PLANNING CONSULTATION RESPONSE

Application No	2026/0713
Proposal	Demolition of existing dwelling and associated outbuildings, with erection of 4no. detached dwellings and garaging
Address	Stone Croft, 1 Hall Royd Lane, Silkstone Common, Barnsley, S75 4PP
Date of Consultation Reply	21/10/2026
Consultee	SYMAS

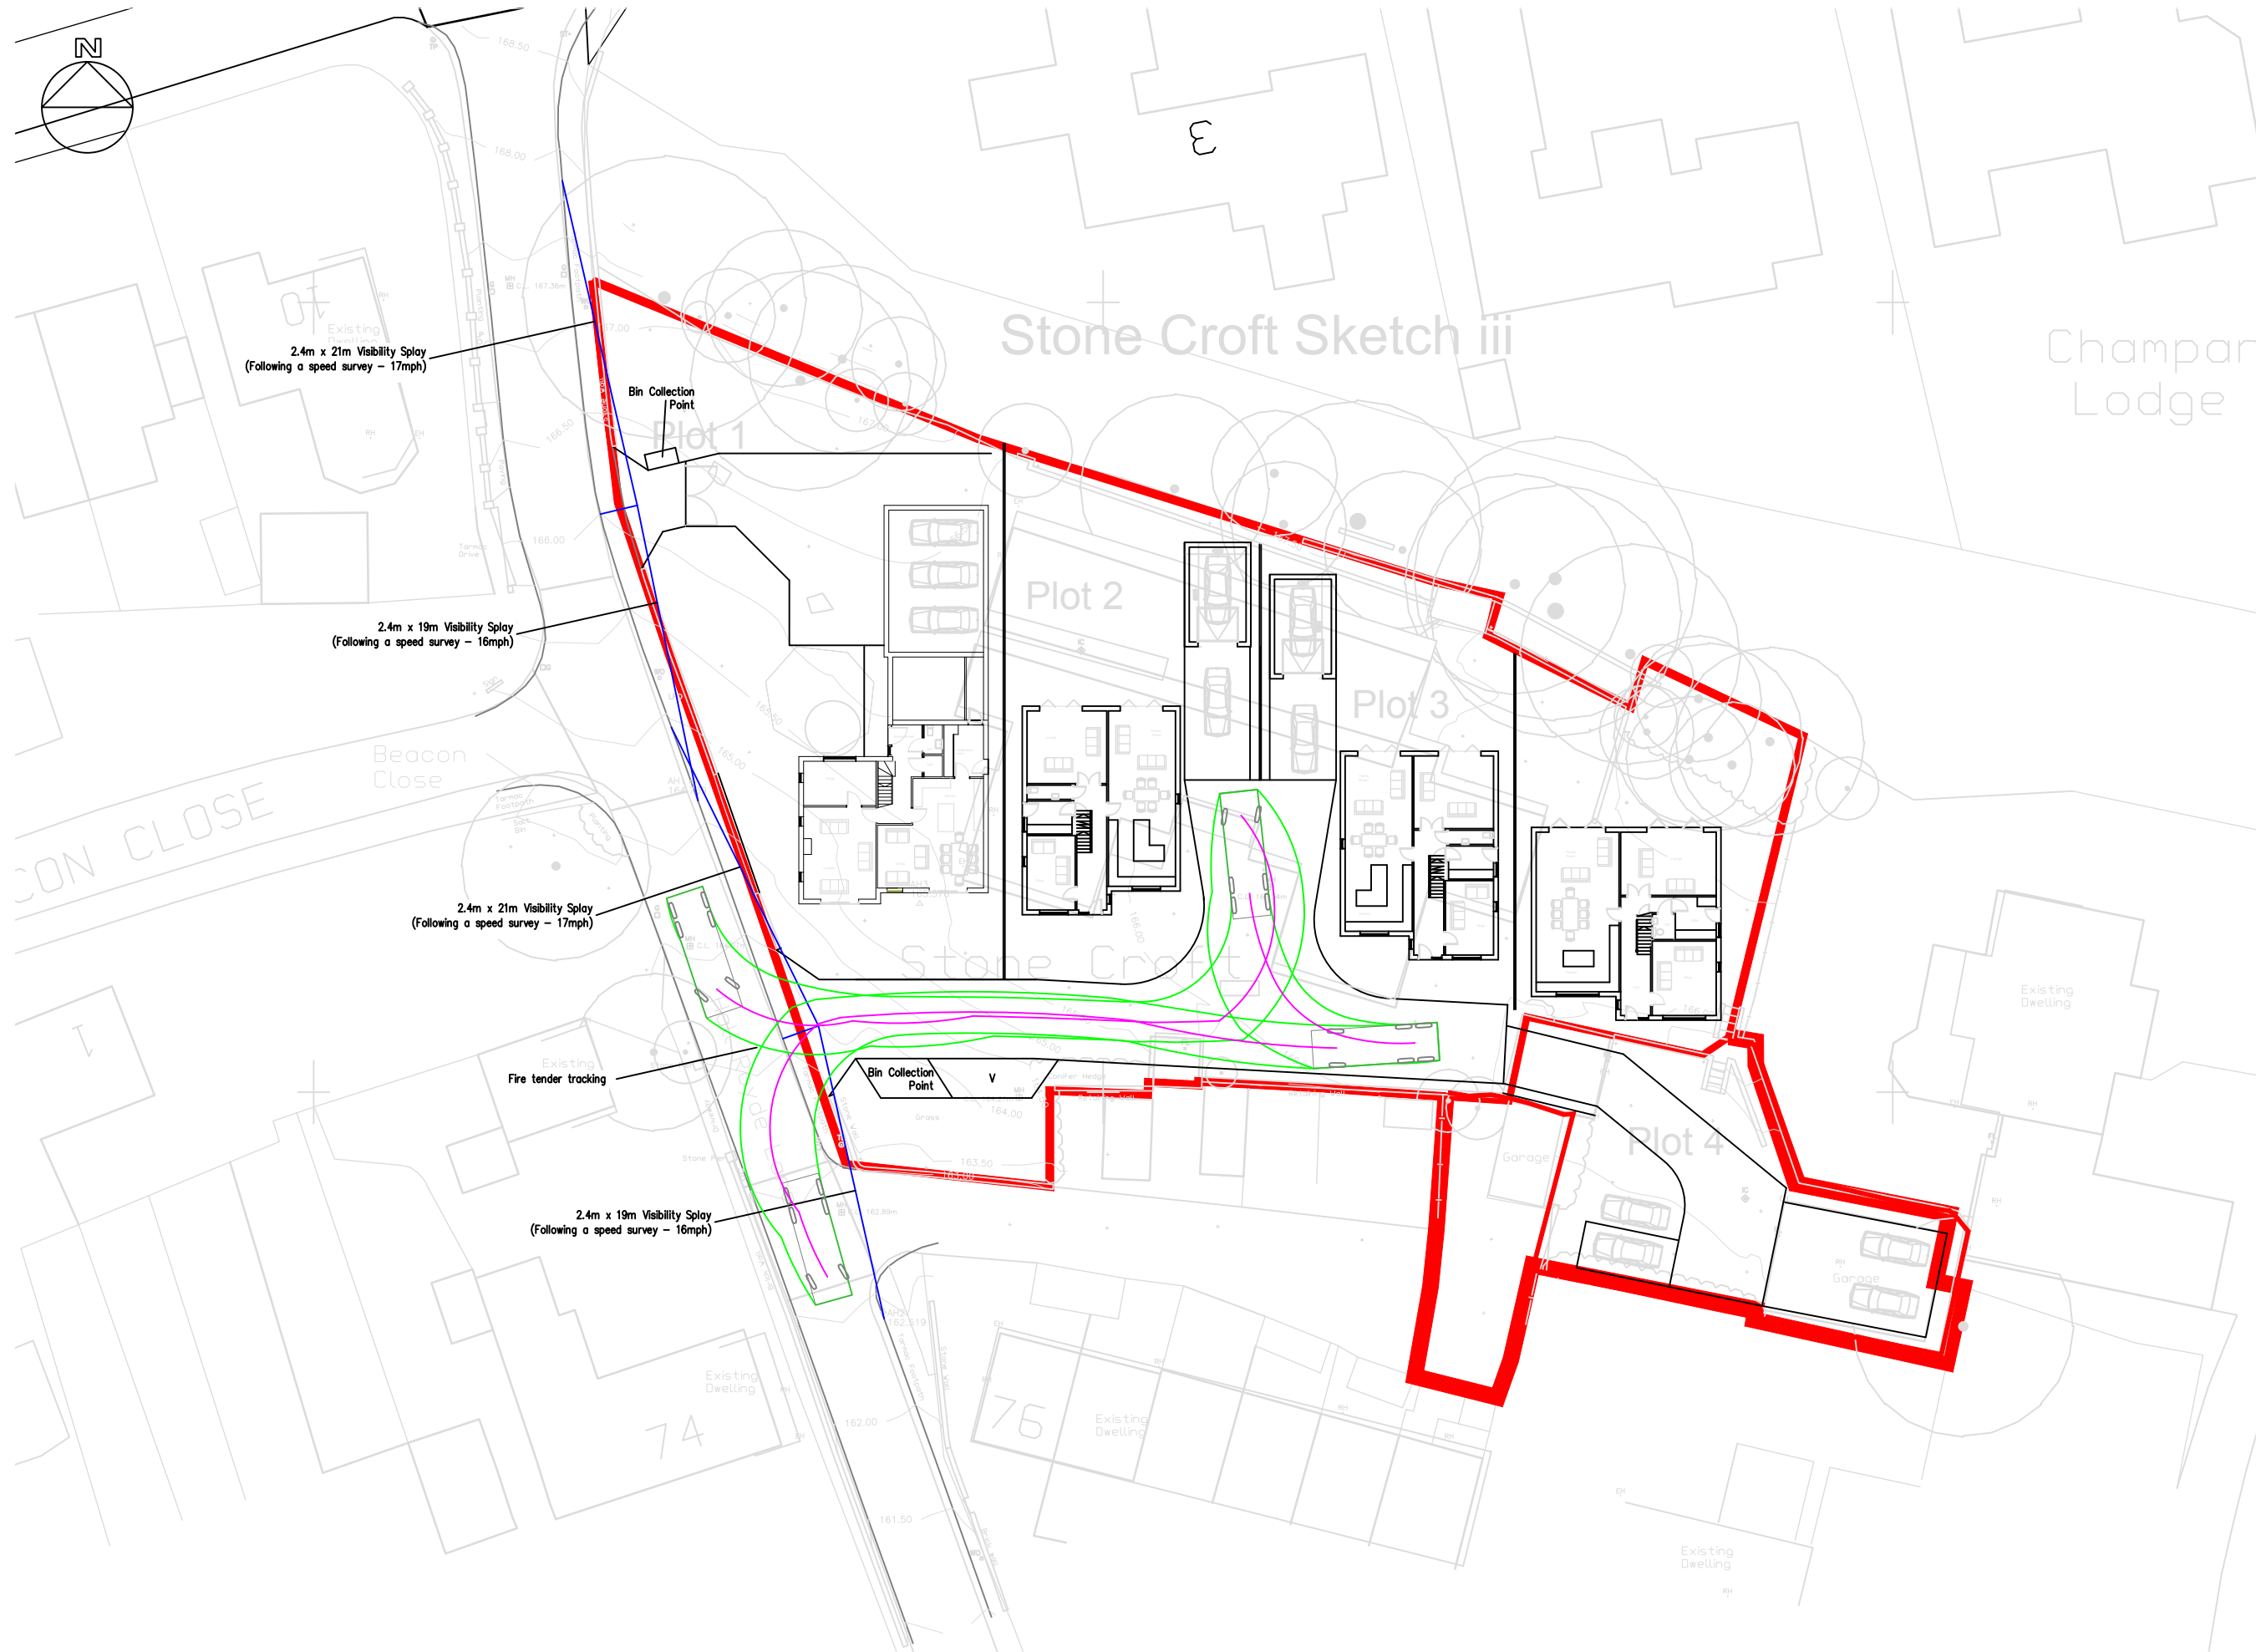
The accompanying proposed site layout shows proposed dwellings and associated garages in close proximity to the mine shaft(s).

From the available information SYMAS is unable to conclude the proposed layout is compliant with Mining Remediation Authority guidance on build development located in close proximity to mine entries and therefore SYMAS is unable to recommend planning approval at this time.
